From: Martyn White <Martyn.White@arun.gov.uk>
Sent: 20 December 2019 15:54
To: Planning.Responses <Planning.Responses@arun.gov.uk>
Subject: AW/296/19/PL

AW/296/19/PL

The application relates to a balcony to the first floor over an existing flat roof and includes a timber screen.

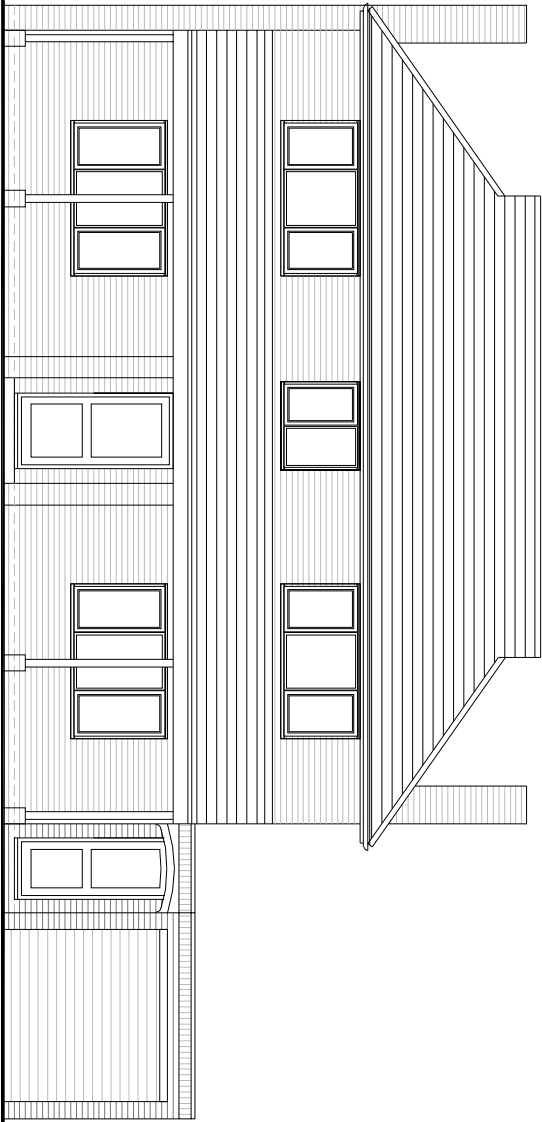
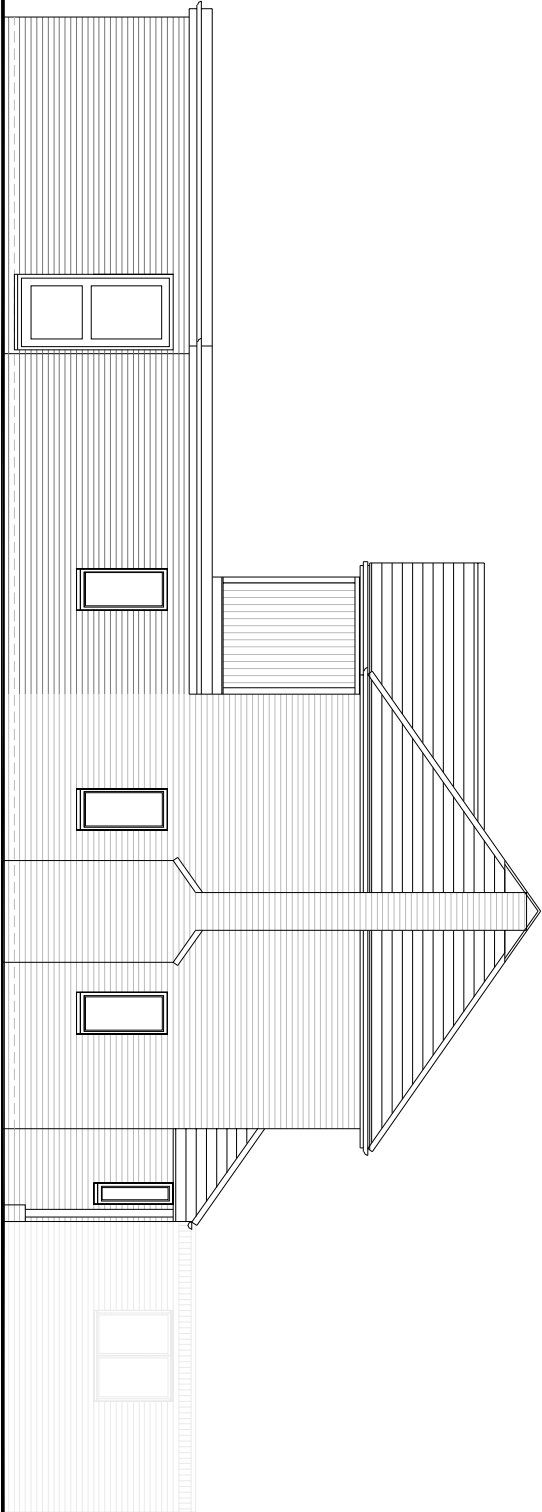
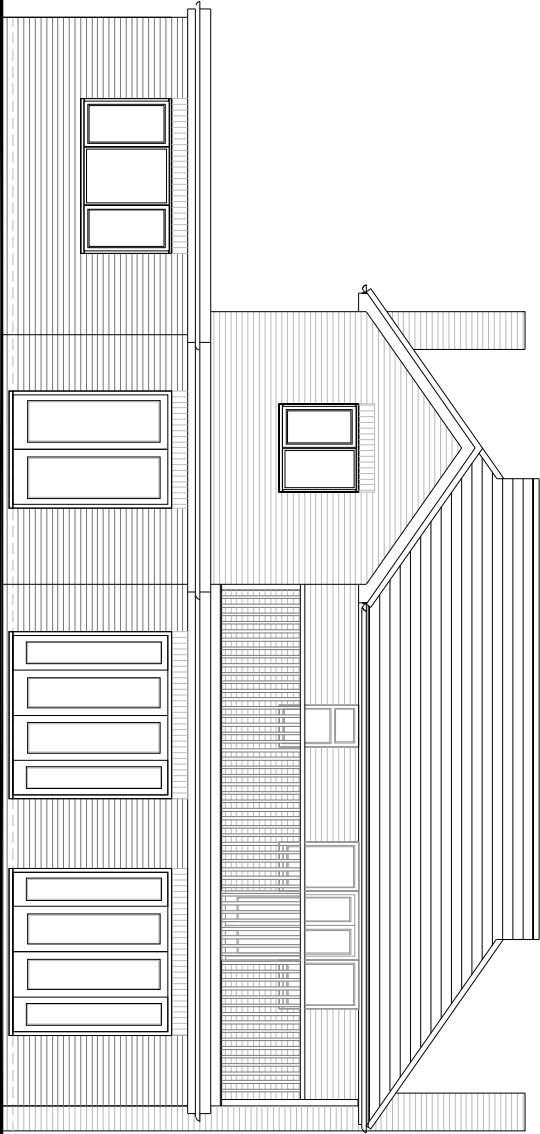
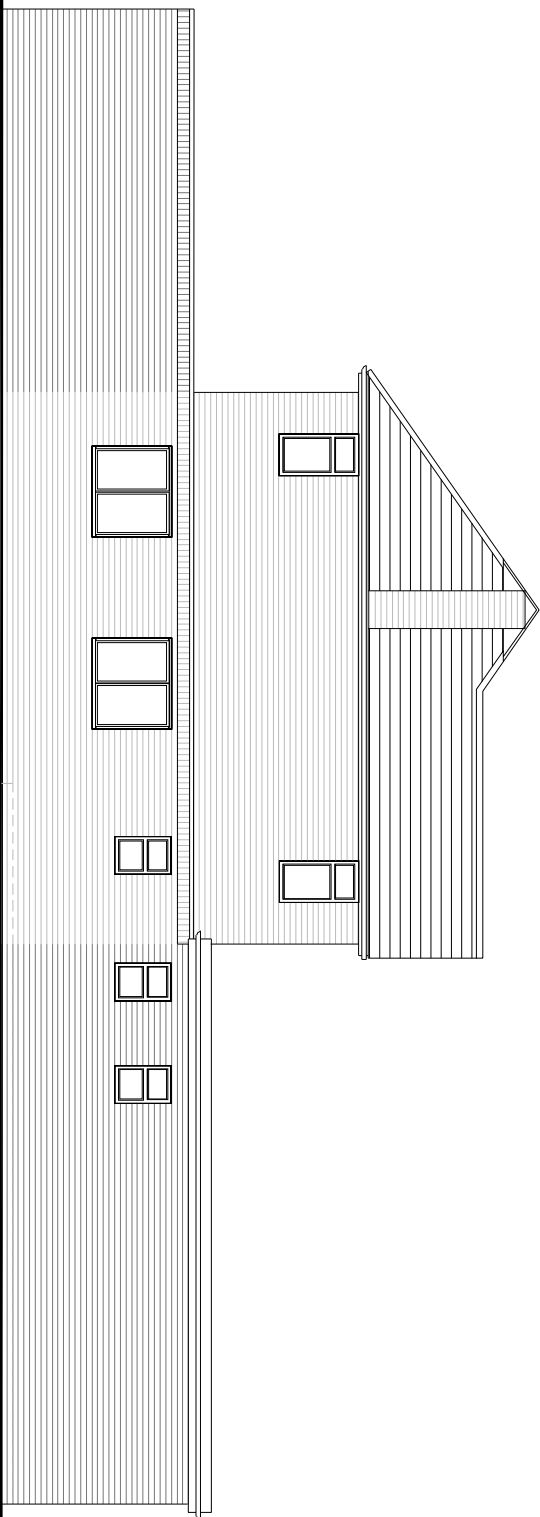
The property is located within the Craigweil House Conservation area, and any proposals should ensure that they do not harm the established character of the area. The location of the balcony and screen is such that it will not be largely visible from the road to the front of the site. The treatment of the timber screen should be considered, and it is suggested that a suitable condition be placed with regards to this.
